**Memorandum  
ABP-319843-24 –  
Request for Further  
Information**

**To:** Una Crosse, ADP  
**From:** Máire Daly, SPI  
**Re:** 319843-24 – Request for Further Information  
**Date:** 29<sup>th</sup> January 2025

DRAWN:	S.R.	CHECKED:	D.T.	APPROVED:	D.T.
PROJECT NUMBER:	23173	DATE:	OCT '23	SCALE @ A1:	1:150
STATUS DESCRIPTION:	FOR INFORMATION			STATUS:	S2
DRAWING NUMBER:	23173 - MWP - 00 - 01 - DR - C - 0105			REV:	P09

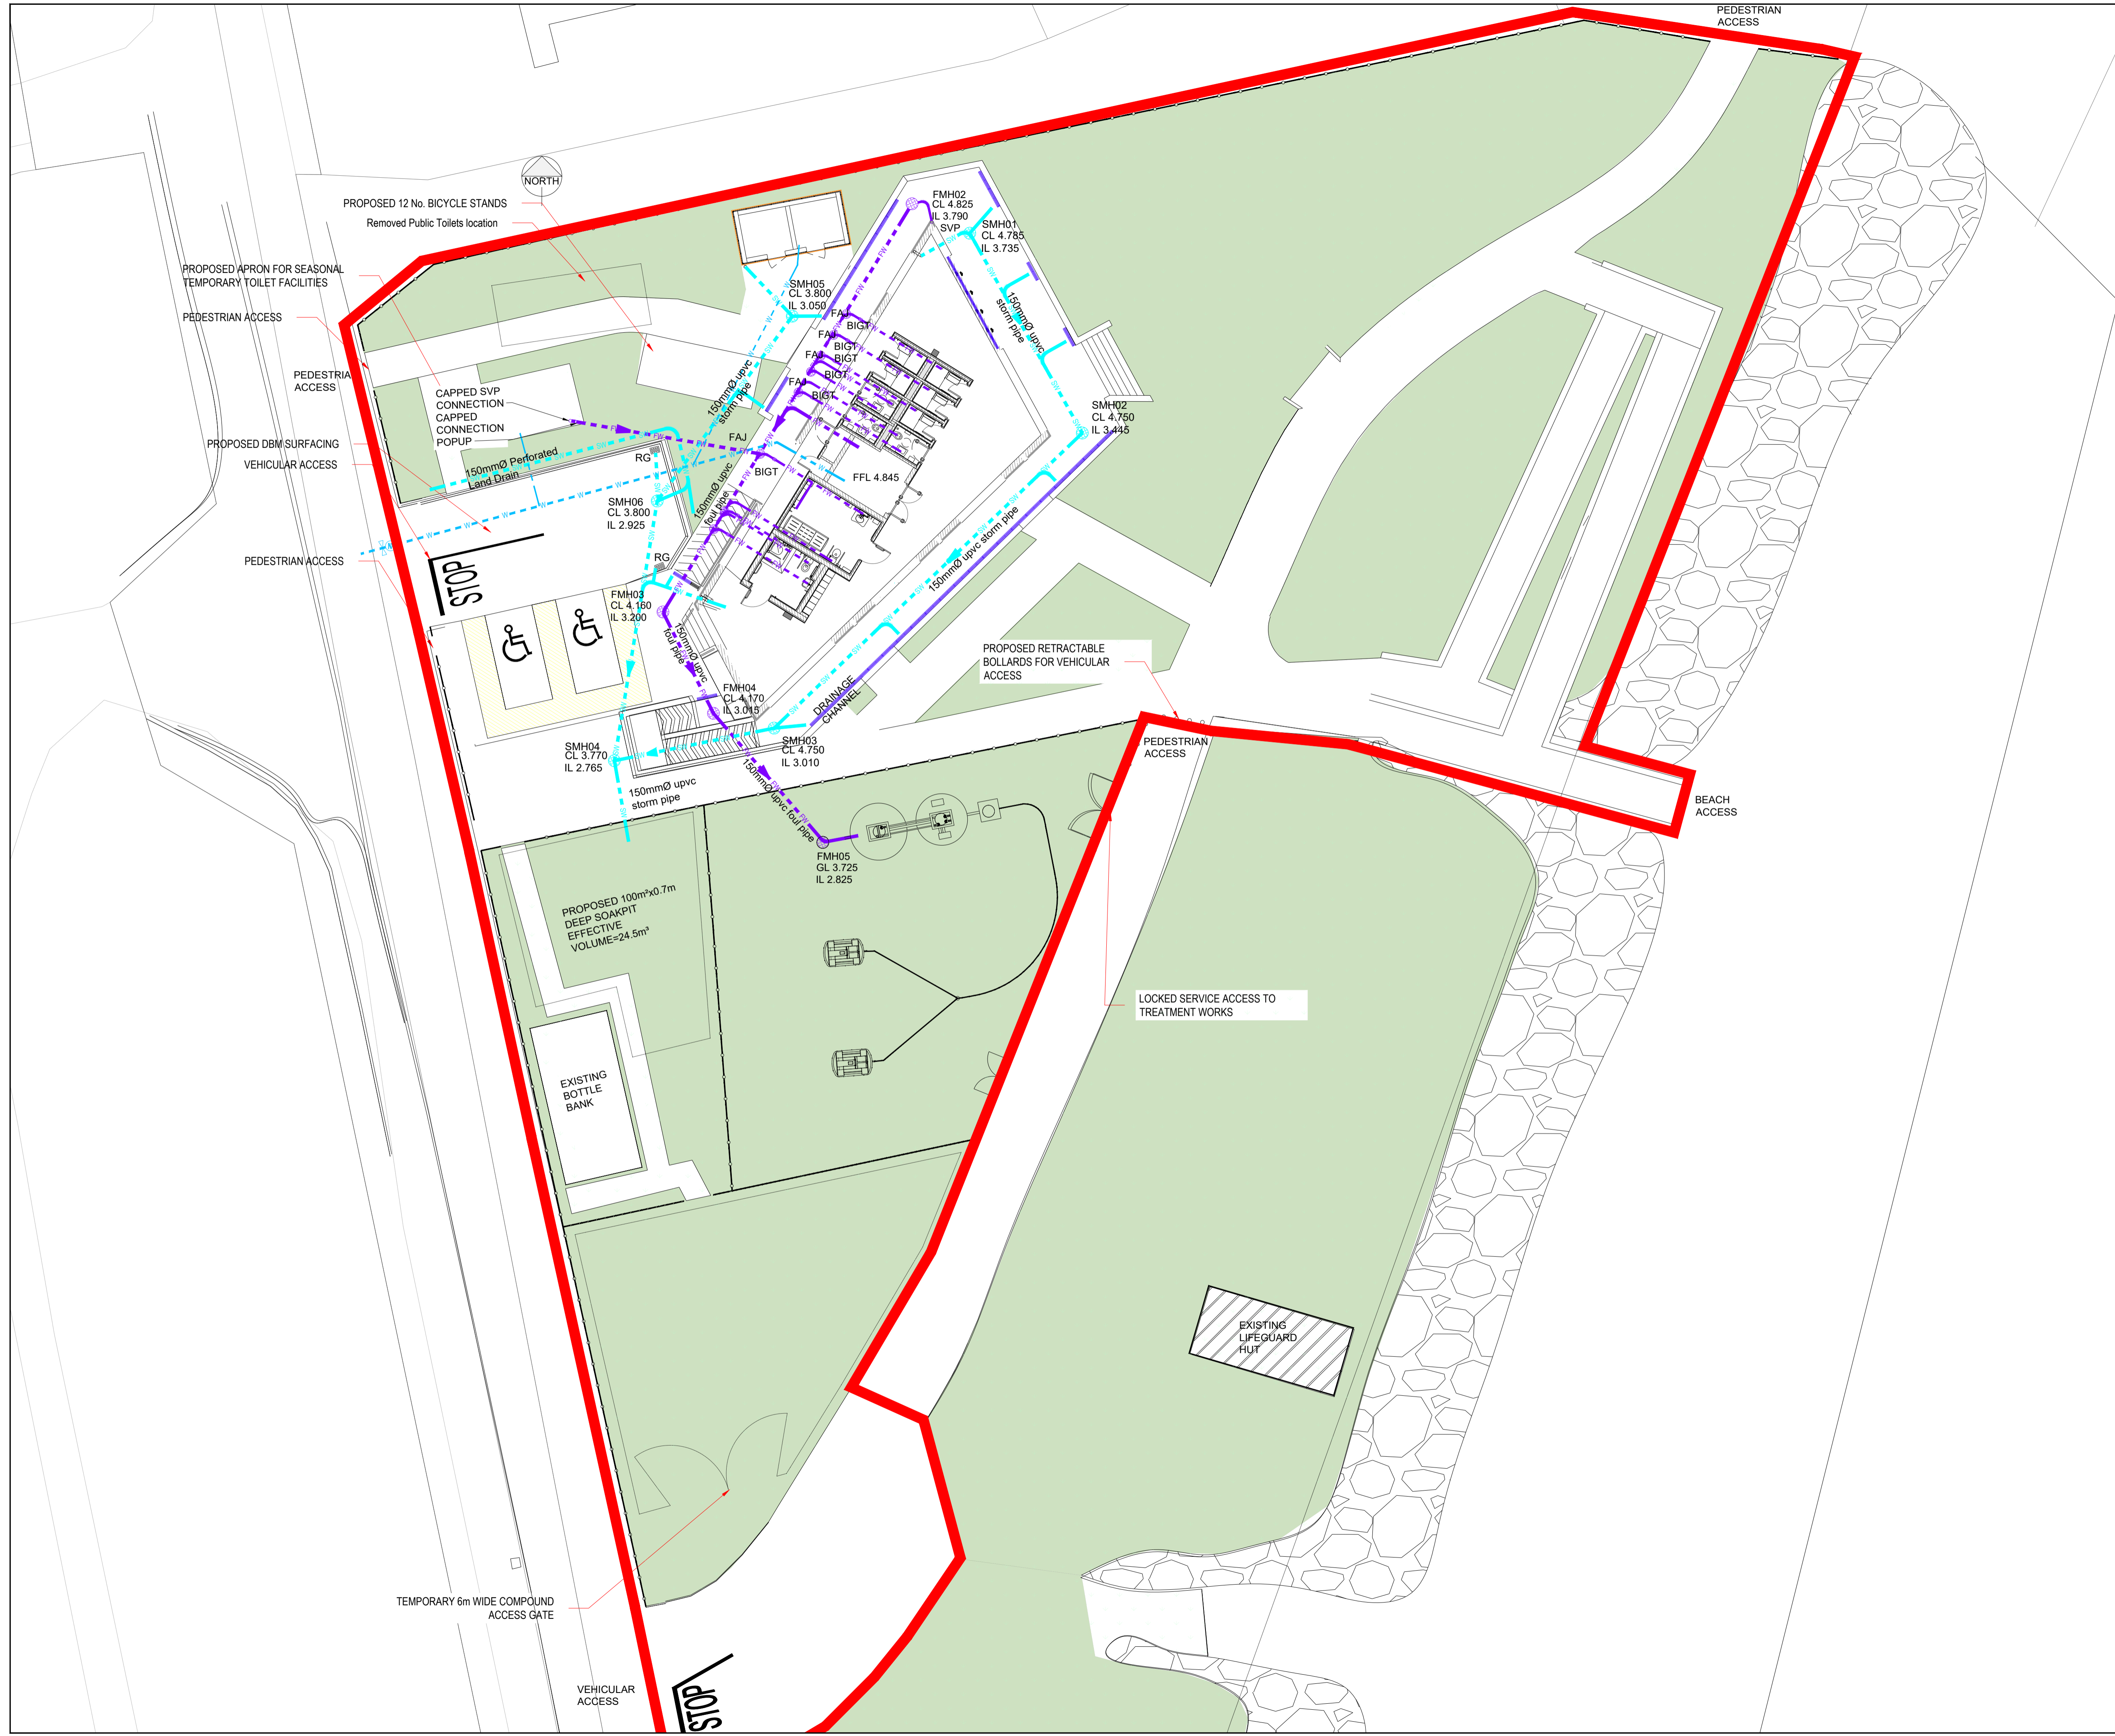
- iii. Identify each unlabelled structure/item shown on the submitted Proposed Water Services Drawing no. 23173-MWP-00-01-DR-C-0105 including items within the vicinity of the underground percolation area and those along the northeastern part of the site, in particular that which is to be connected to the proposed foul drain. The existing toilet block on site should be removed and the updated site layout plan should reflect this.

- iv. Correctly identify the area where the proposed underground percolation system is to be located, this location should also be reflected on Drawing no. 23173-MWP-00-01-DR-C-0105 and referred to in an updated NIS. In addition the NIS should be updated to include the most up to date version of drawing no. 23173-MWP-00-01-DR-C-0101.
